Public Rights of Way consultation

Planning application : 2018/90283

Address : 1 Mount Pleasant, Stanley Lane, Golcar

Proposal : Erection of single storey side and rear extensions and demolition of existing single storey extension (within a Conservation Area)

Site Plan 1:200

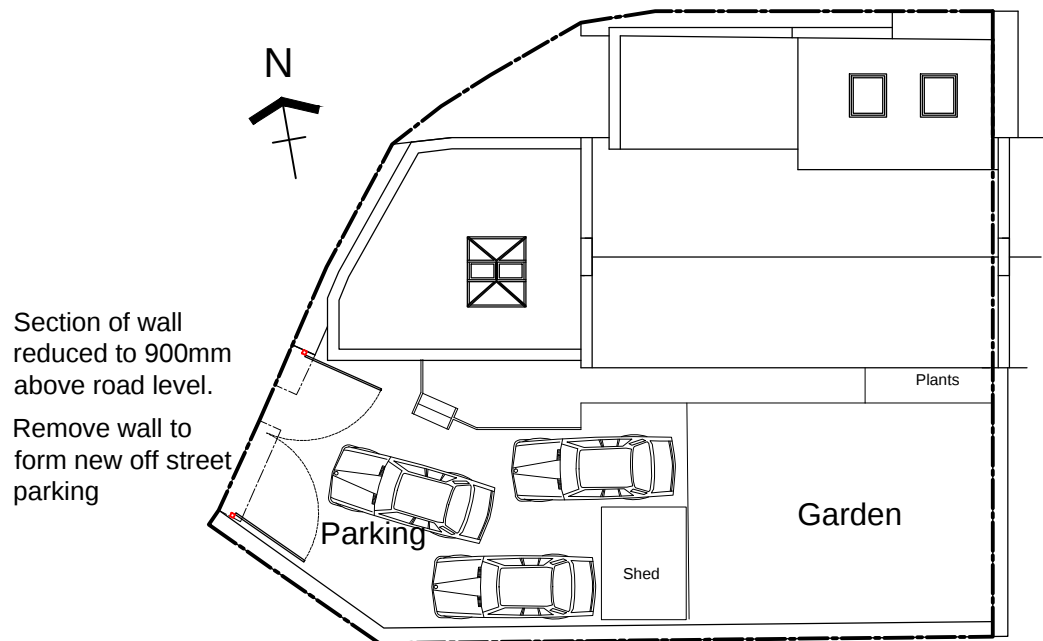
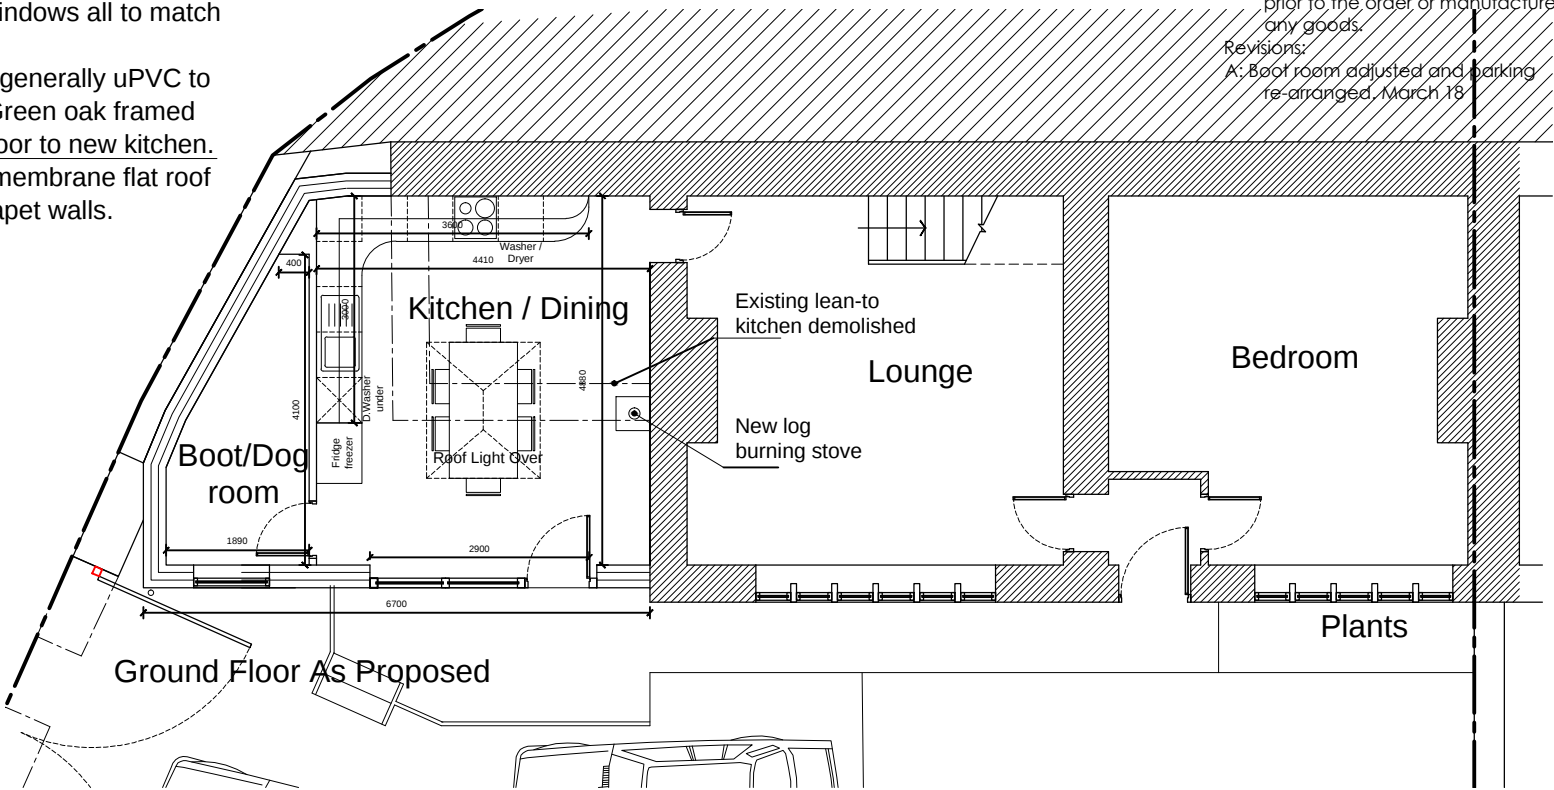
The gates indicated for the new parking should not open out onto the footpath
